Our Ref: M/21/22/NMA

Non-material amendment following grant of M/103/20/HH for the change roofing material on the northeast wing renovation from Corten steel to black coated corrugated steel; change the position of the stove and chimney in the northeast wing from the centre of the sitting room east wall to be in the northeastern corner of the room; Include an additional stove in the kitchen/dining area to the left of the french doors on the courtyard side; Reduce number of skylights in the kitchen on the west side from 3 to 2 and change the dimensions of all kitchen skylights from 150x150cm to be 134cm width x 140cm length; Reduce the length and position of the window running down the side of the front door in the courtyard from full length to more standard window dimensions, matching the guest bedroom length at the east end of the building.

Ancton Barn Ancton Lane Middleton-on-Sea PO22 6NJ

203109/ 04

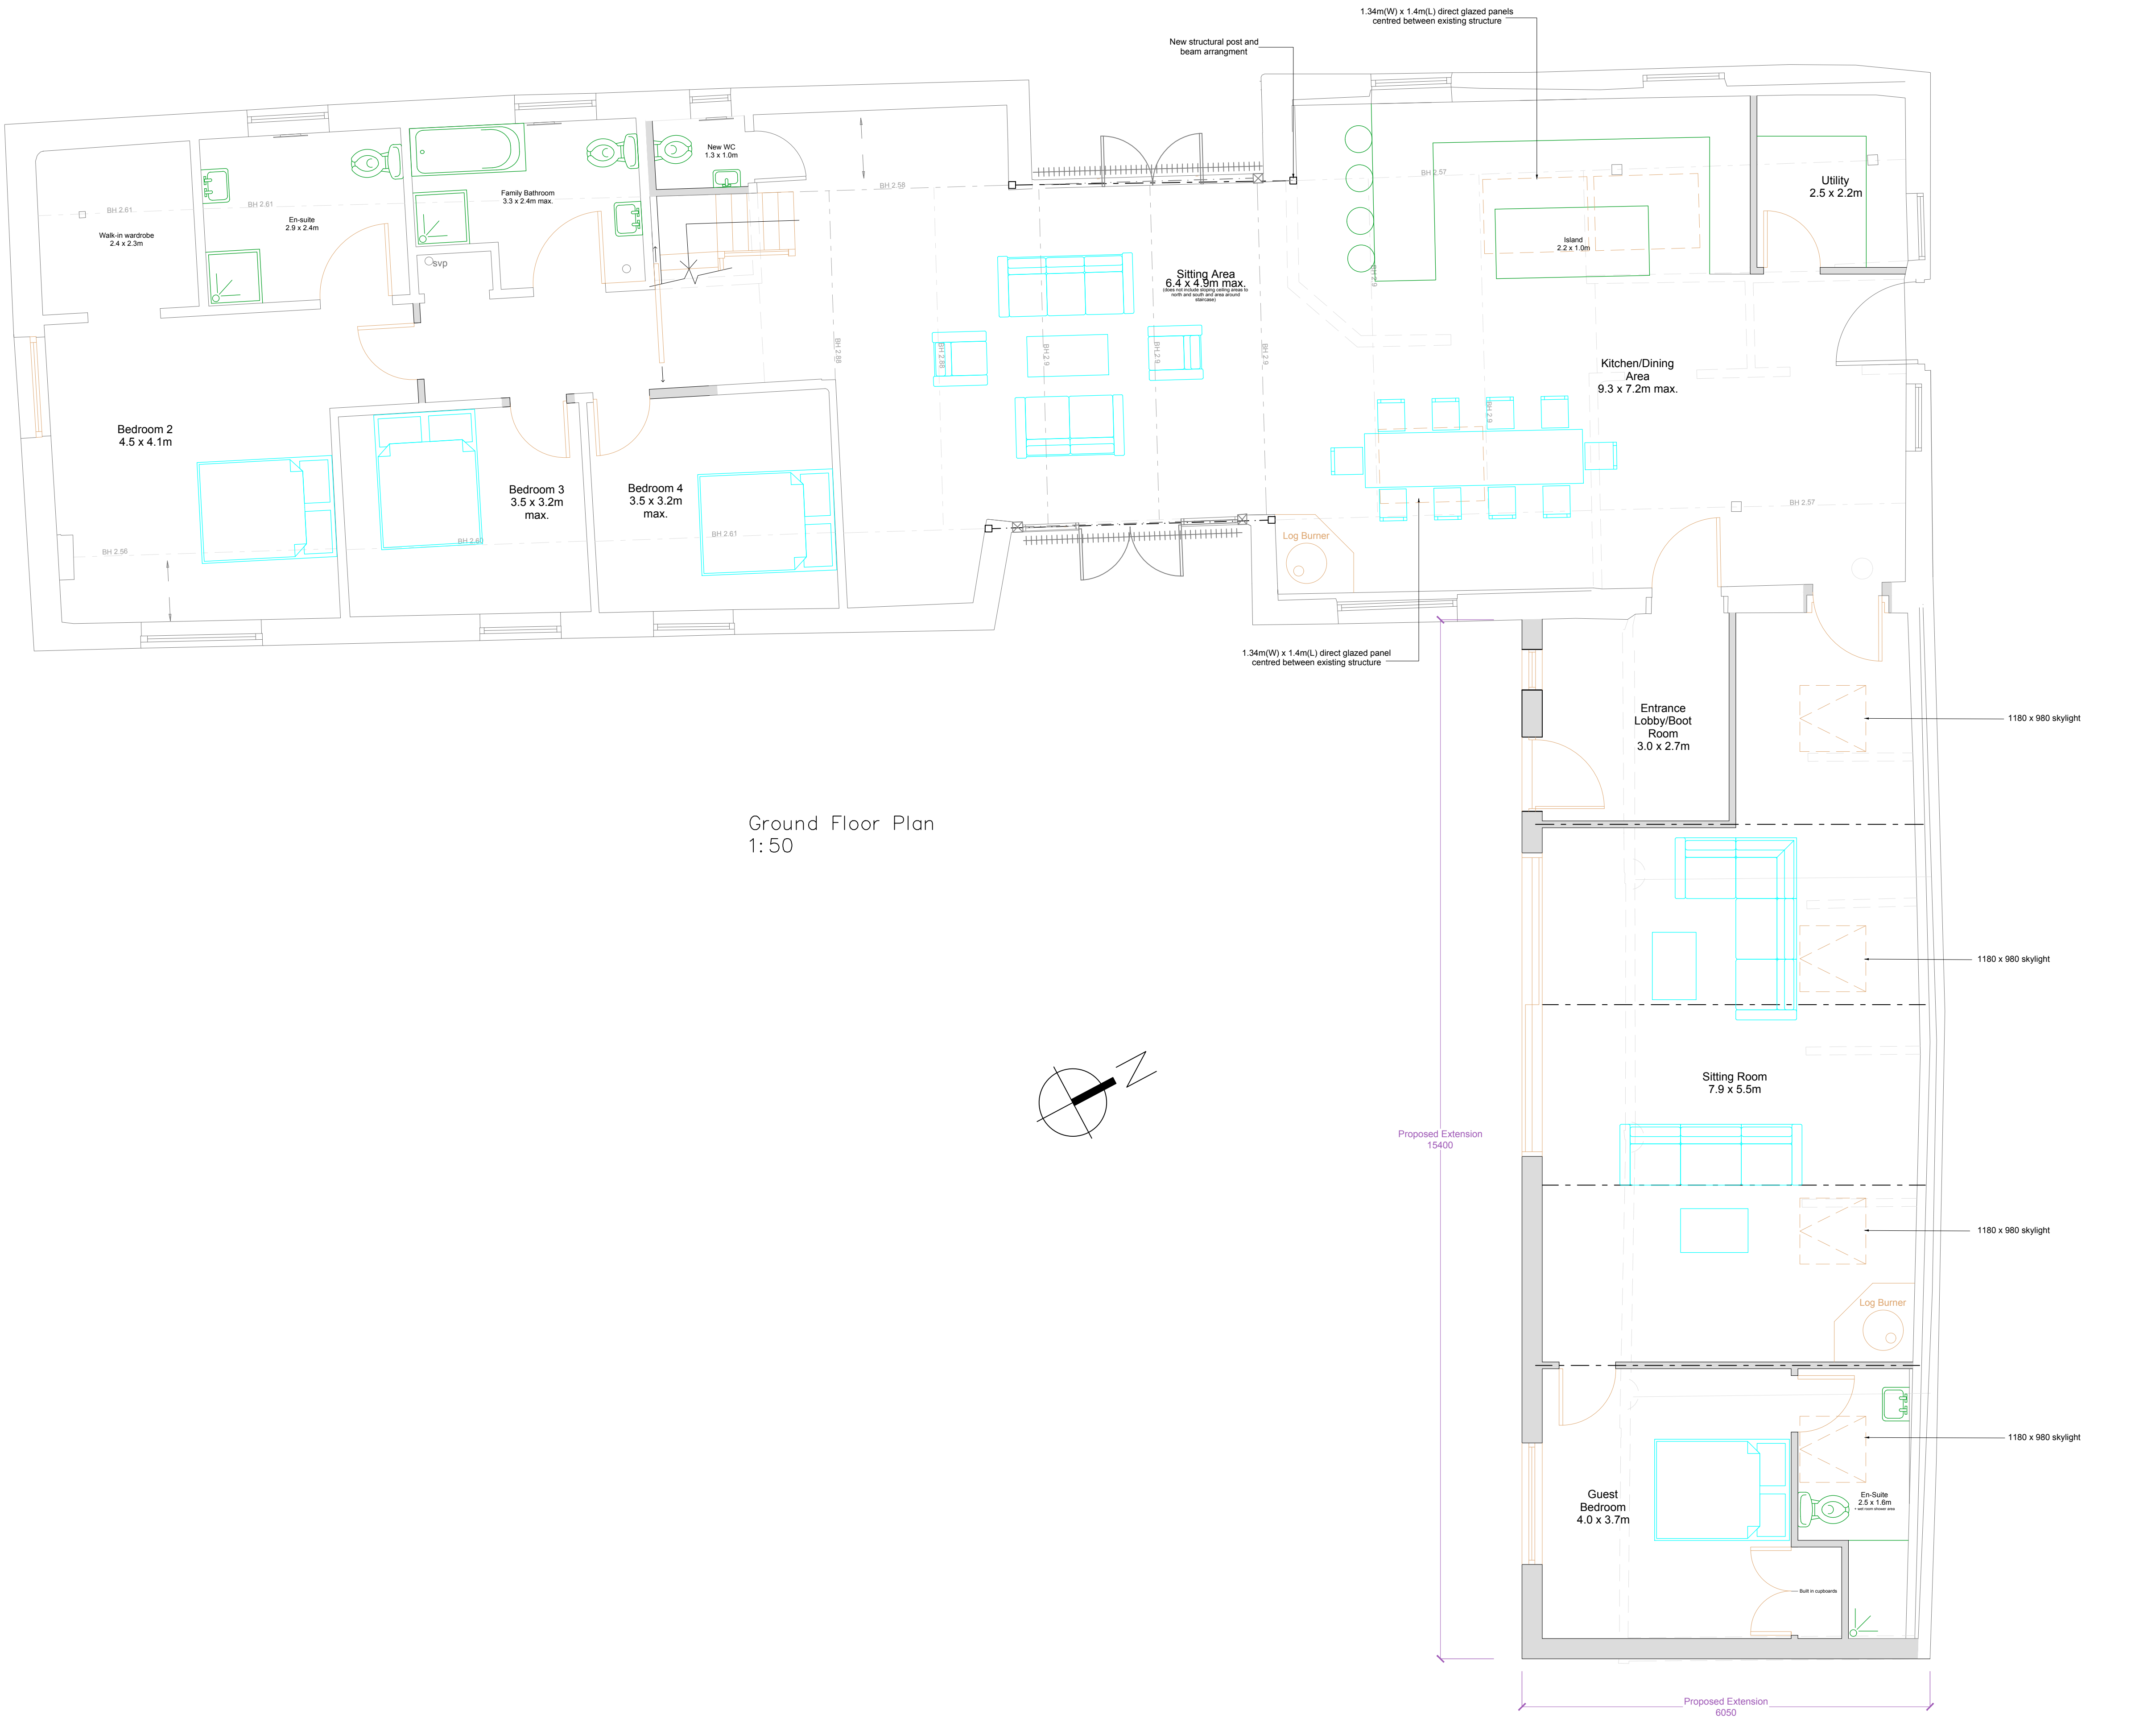
chimney in the north-eastern wing would be moved from the centre of the sitting room east wall to the north-eastern corner of the room; an additional stove and chimney would be install in the kitchen/dining area left of the French doors on the courtyard side.

There would be further changes in fenestration arising from the revised internal layout; the number of skylights in the kitchen on the west side would be reduced from 3 to 2 and one of the two approved skylights on the eastern elevation would be removed due to insertion of a new chimney; the size of all kitchen skylights would be reduced from 150cmx150cm to 134cmx140cm; the length of the window running down the side of the front door in the courtyard would be reduced from full length to more standard window dimension and its position would be changed.

Please note that the drawing 203109/04 Rev B replaces the originally approved drawing 203109/04, the drawing 203109/05 Rev B replaces originally approved drawings 203109/05, the drawing 203109/06 Rev B replaces the drawing 203109/06 and the drawing 203109/07 Rev A replaces the drawing 203109/07 Rev B.
